SSD 9351535 – JOHN HUNTER HEALTH AND INNOVATION PRECINCT REQUEST FOR ADDITIONAL INFORMATION

On behalf of the applicant, Health Infrastructure, this submission has been prepared by Ethos Urban in response to the Department of Planning, Industry and Environments (the Department) Request for Additional Information dated 16 September 2021 regarding the above application.

FIGURE 3.1
Vegetation Mapping and
Integrity Plot Survey Locations

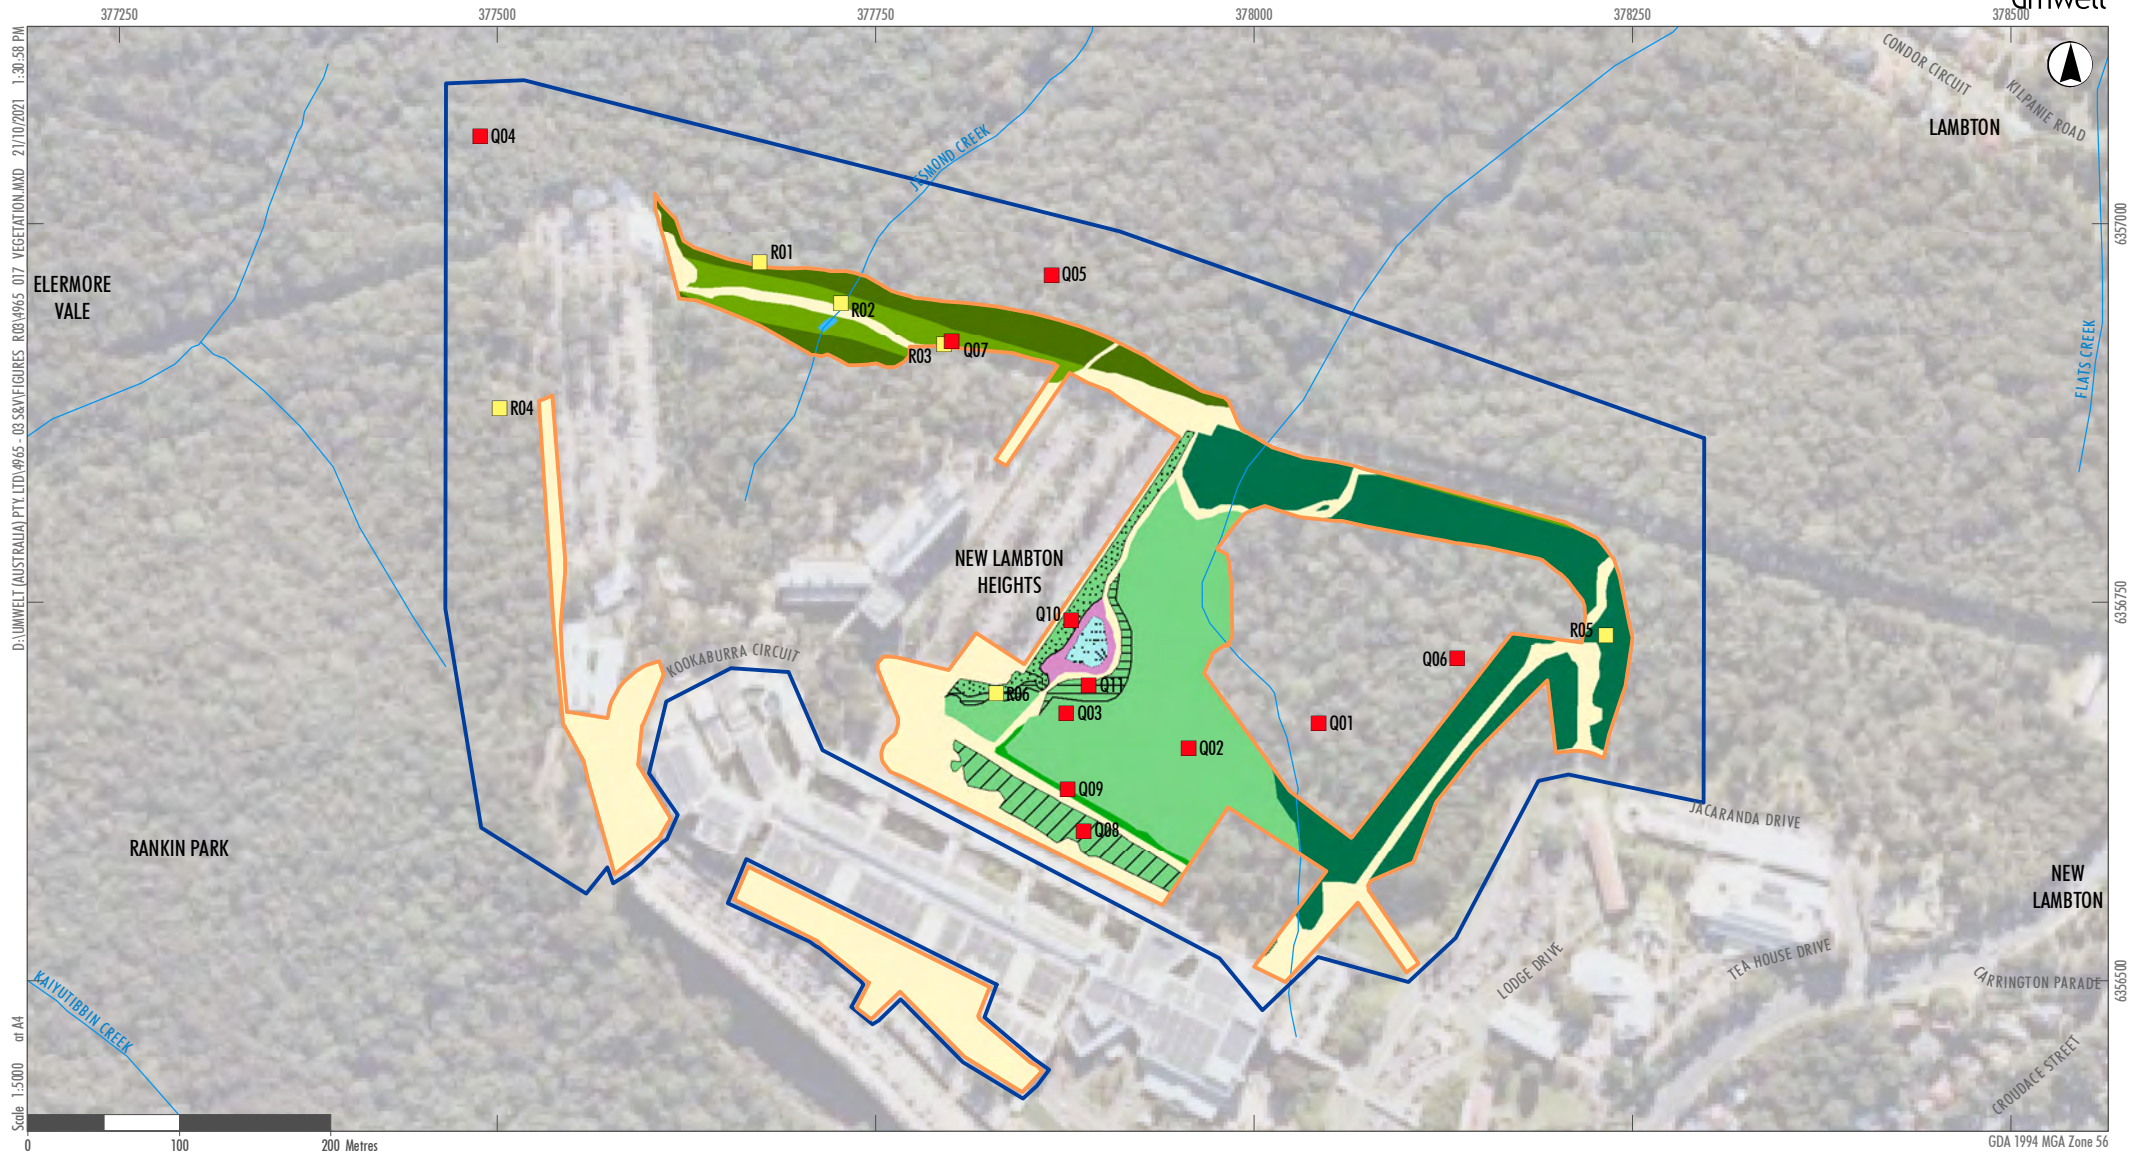
<p>Biodiversity and Conservation Division</p>		
<p>BCD recommends that the proponent samples and assesses the native vegetation in the powerline easement within the development footprint accordance with the Biodiversity Assessment Method 2017.</p>	<p>The meeting of 28 September 2021 Umwelt and BCD have agreed on the changes required to address this comment. The amended BDAR is attached.</p>	<p>Appendix E</p>
<p>BCD recommends that the Site Map is redrawn so that the extent of native vegetation assessed for the project is presented at no more than 1: 10,000 scale.</p>		<p>Appendix E</p>
<p>Transport for NSW</p>		
<p>Construction Management – The Construction Traffic Management Plan, coordinated through the NICB / JHH steering committee, should be required prior to the commencement of any works on-site. The development should seek to mitigate traffic related impacts from the development with initiatives such as construction works outside of peak traffic volume periods, park and ride shuttle bus services and car-pooling.</p>	<p>Noted.</p>	<p>-</p>
